Application Reference Number:	2026/0107		
Application Type:	Householder		
Proposal Description:	Erection of detached double garage		
Location:	30A Fearn House Crescent, Hoyland, Barnsley, S74 0BA		
Applicant:	Mr Neil Whitlam		
Third-party representations:	None	Parish:	None
		Ward:	Rockingham

This planning application seeks householder planning permission for the erection of detached double garage. A previous application for a double garage 2023/0906 was refused at the same site.

Proposed Front Elevation

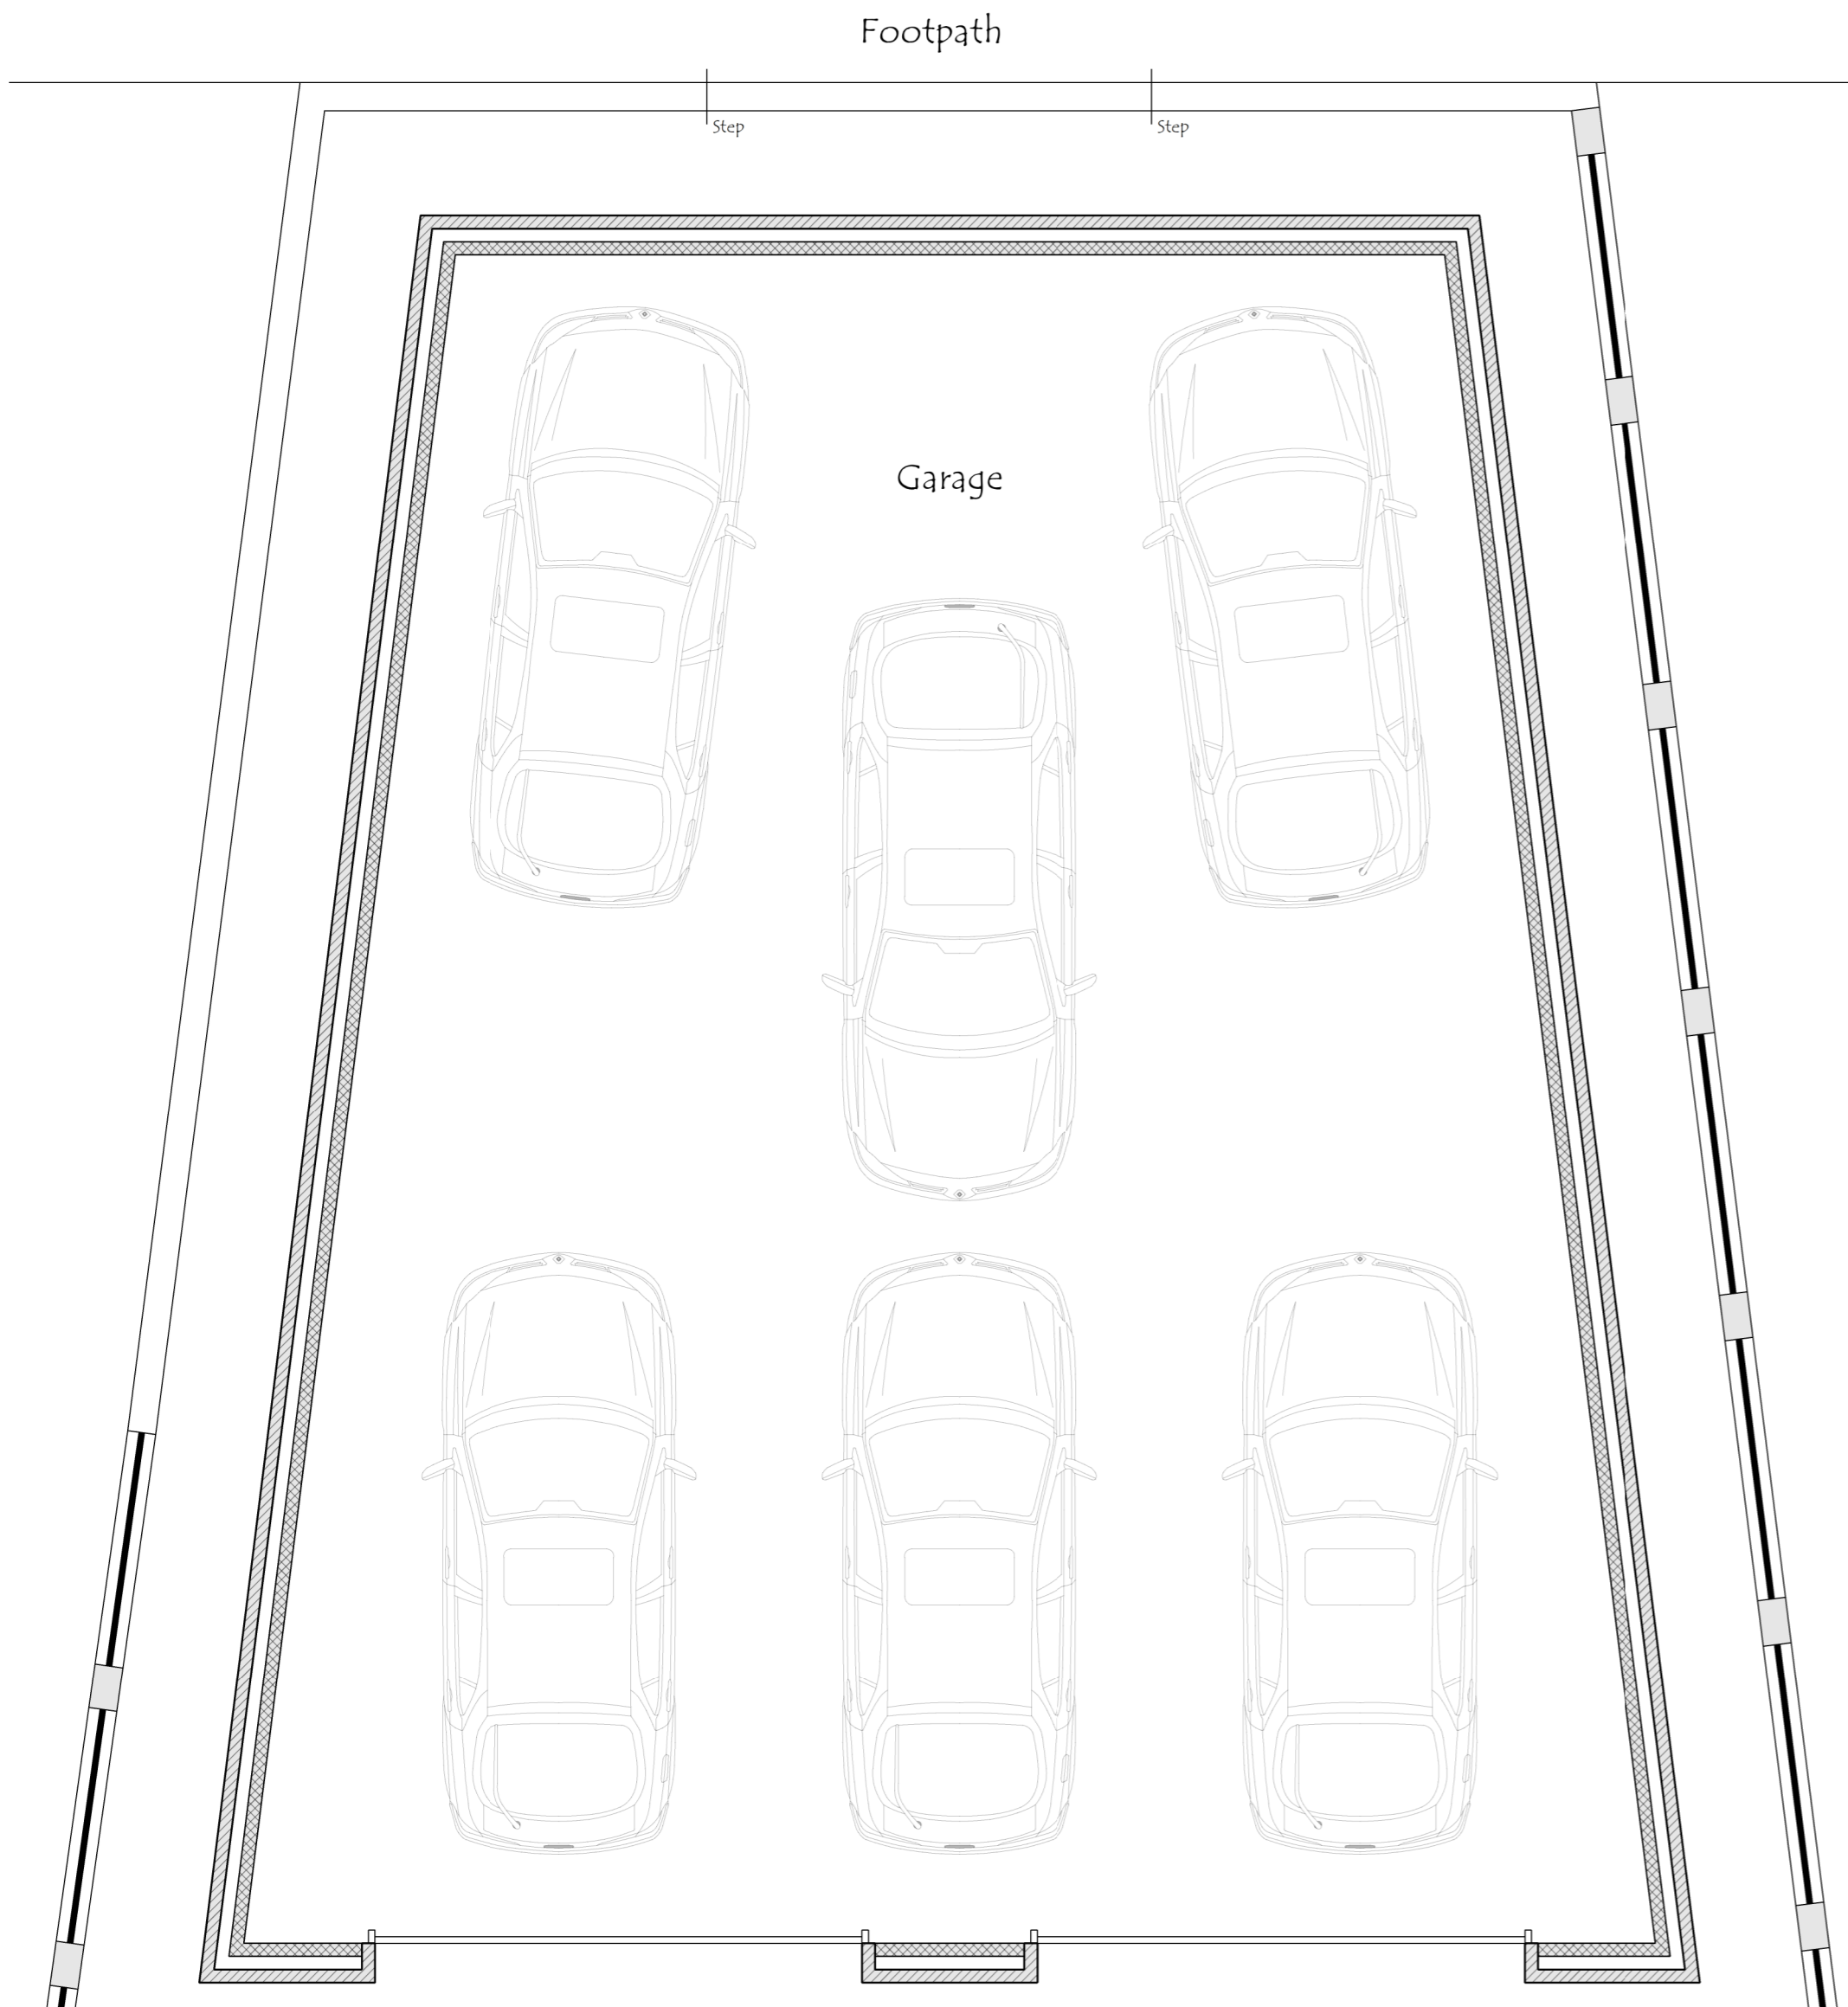
The SPD states that “*detached garages and outbuildings should be single storey structures and the eaves height should not normally exceed 2.5 metres from ground level, whilst the ridge height should not exceed 4 metres*”. The proposed garage has a pitched roof with an eaves height of 2.35 metres which is compliant. However, the proposed garage is a tall structure for a single storey and would have a ridge height of 5 metres. The additional roof height over the guidance of the SPD is not acceptable.

Although reduced in height from the previous refusal the proposed garage is still a tall structure at 5 metres in height and in conflict with the guidance above. There is no justification given for the proposed height which goes over and above the required height for that needed for the parking of motor vehicles. This weighs significantly against the proposal.

As noted above the proposed garage has an excessive height exceeding that of the SPD guidance and it is also large in scale with a footprint greater than the previously refused garage at this property. The garage would not appear as that of an ancillary outbuilding. Whilst the host dwelling is set back from the road, it will be highly visible from neighbouring properties, and it is considered to punctuate the character of development in the area. It is considered that a garage of this size and scale would appear as an incongruous and dominant feature and would be at odds with the general development pattern of the area and would harm the visual amenity of the area in conflict with Local Plan Policy D1. This weighs significantly against the proposal.

The proposed garage would be a very large structure in terms of both footprint and internal floor space. The internal floor space of the garage measures 118sqm which is greater than the previous refused garage. This floorspace is excessive for a domestic outbuilding and would exceed the minimum floorspace expected for a four bedroomed dwelling in the adopted South Yorkshire Residential Design Guide (SYRDG) of 93sqm. The size of the garage is therefore greater than the required size of a new large dwelling. The proposed garage has a larger footprint than the dwellings to the south. This weighs significantly against the proposal.

Proposed Ground Floor Plan

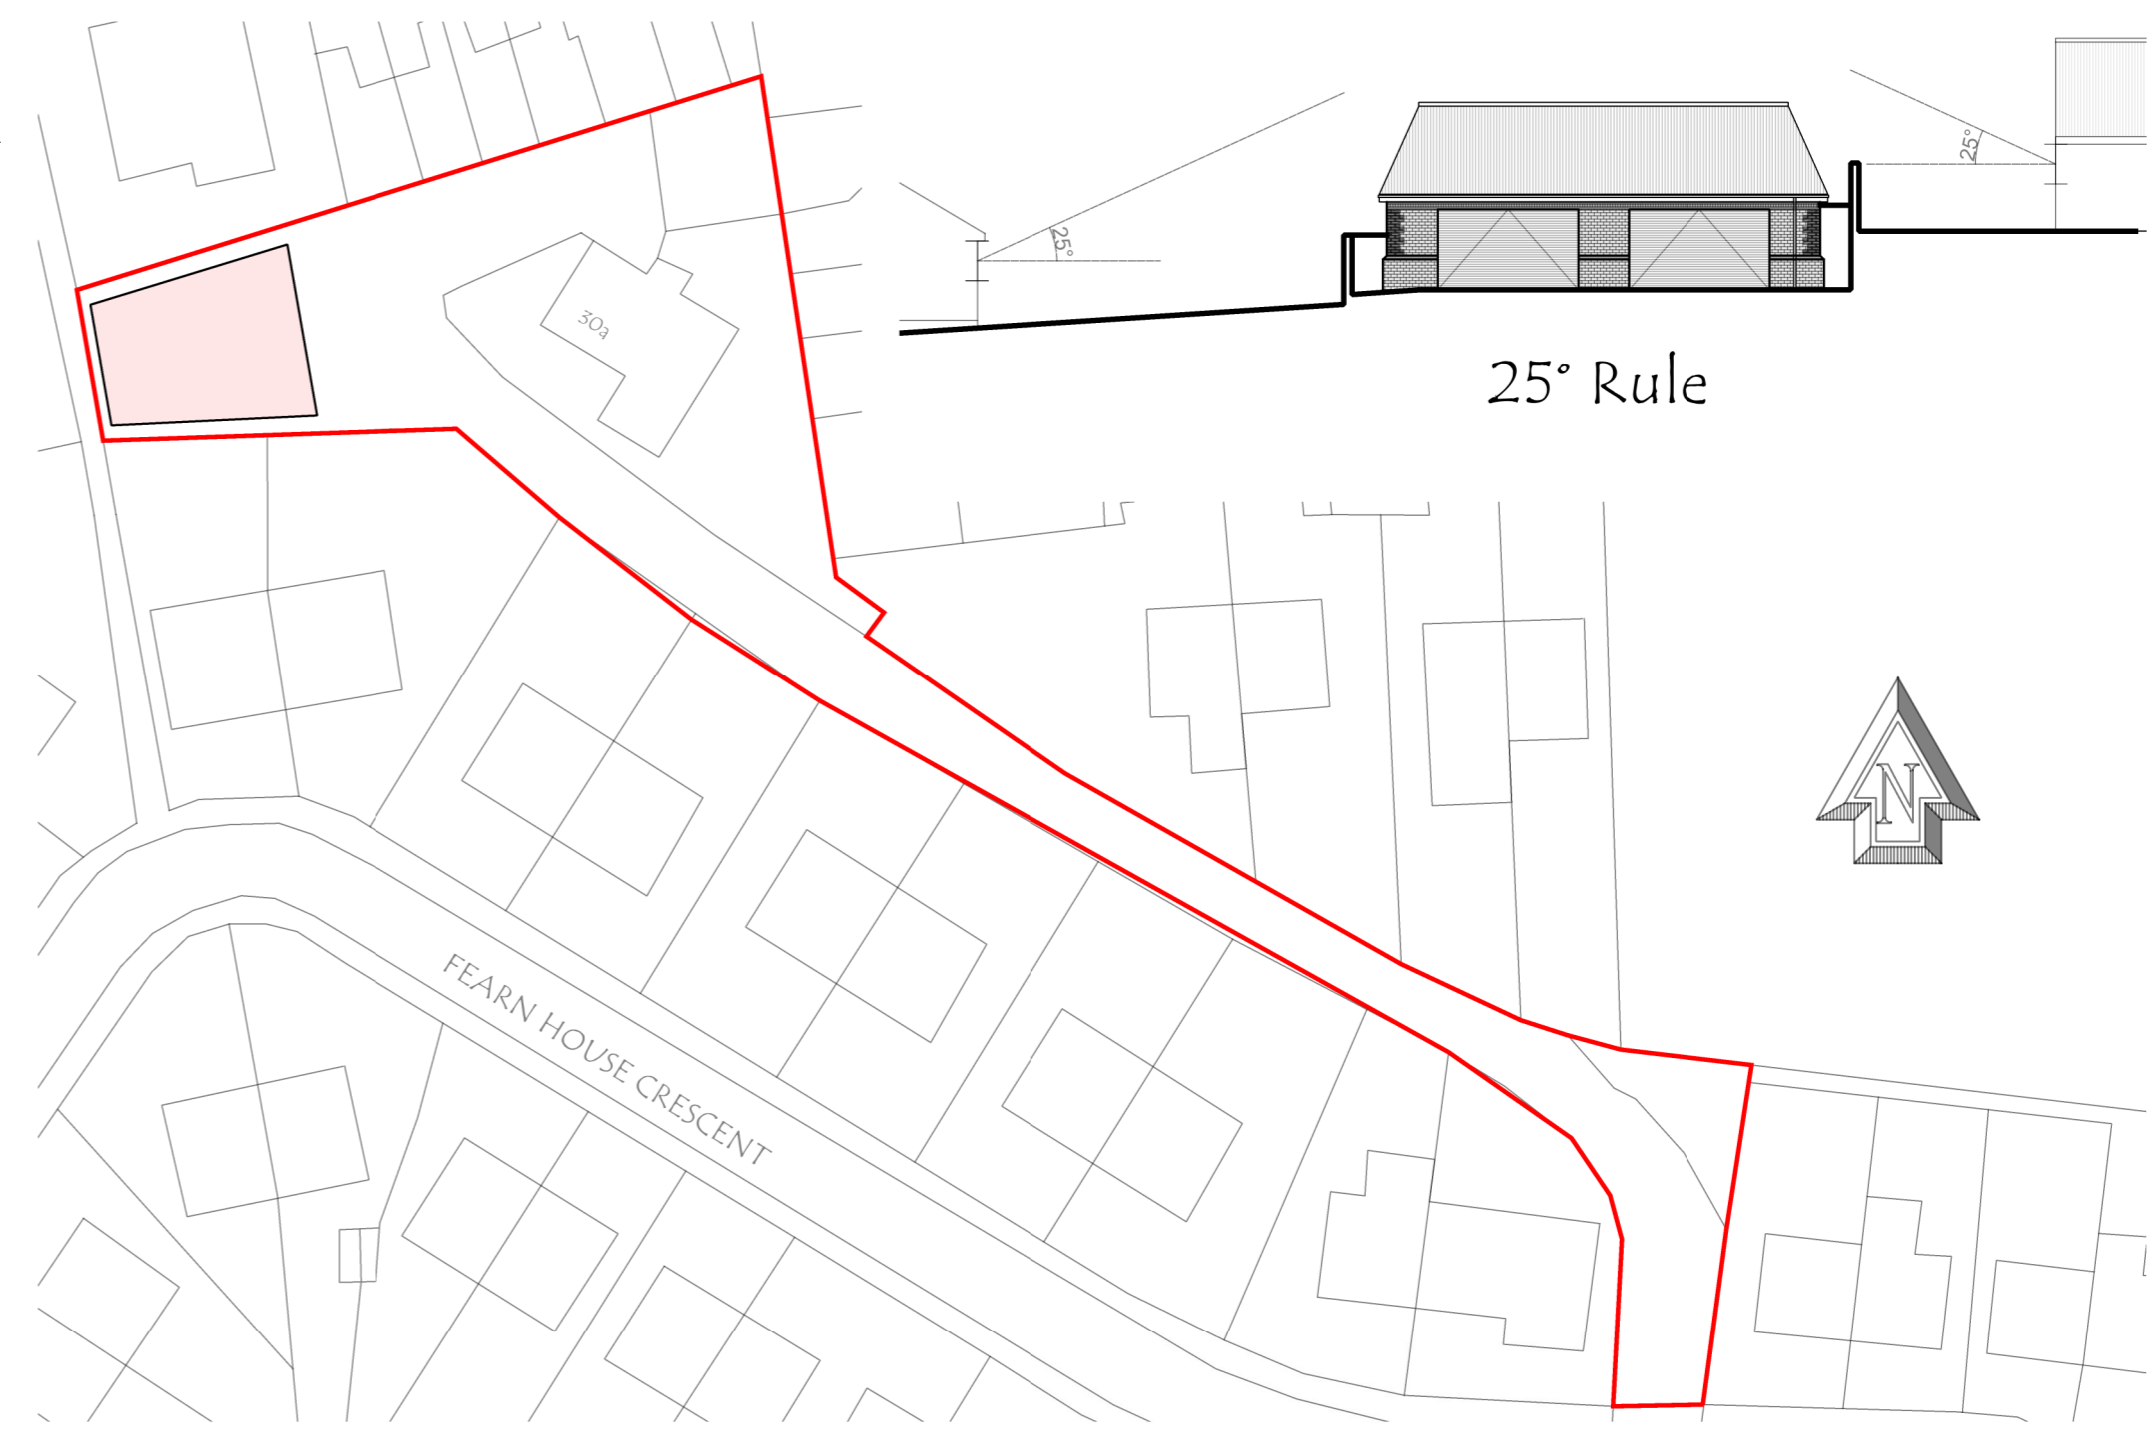
Single storey residential properties are set directly to the side (north & south) of the proposed garage. These properties are 282A West Street to the north and 12 & 14 Fearn House Crescent to the south. The SPD states with regards to habitable room windows that “*a distance of 12 metres should be maintained to a blank gable wall*”. In this case the blank gable wall is that of the proposed garage. The habitable room windows on the rear elevation of 282A West Street are 7 metres away from the proposed garage which is 5 metres short of guidance and therefore unacceptable as it would affect the outlook of these residents. This weighs substantially against the proposal.

The habitable room windows on the rear elevation of 12 & 14 Fearn House Crescent are 11 metres away from the proposed garage which is 1 metre short of the guidance and although not as egregious as the impact would be to 282A West Street, it is still unacceptable. The proposed garage would be considerably overlooked from the adjacent dwellings and cause a harmful loss of outlook to the rear elevations of the impacted dwellings.

The SPD states that *“proposals for garages will be assessed using the reference of a standard size for a single garage as outlined in the South Yorkshire Residential Design Guide, for double garage proposals a standard floor area size is considered to be 6.5m x 6.5m”*. Whilst it is acknowledged that the proposed garage is proposed to be a large garage, it is nevertheless considered that it is in conflict with the SPD on this point.
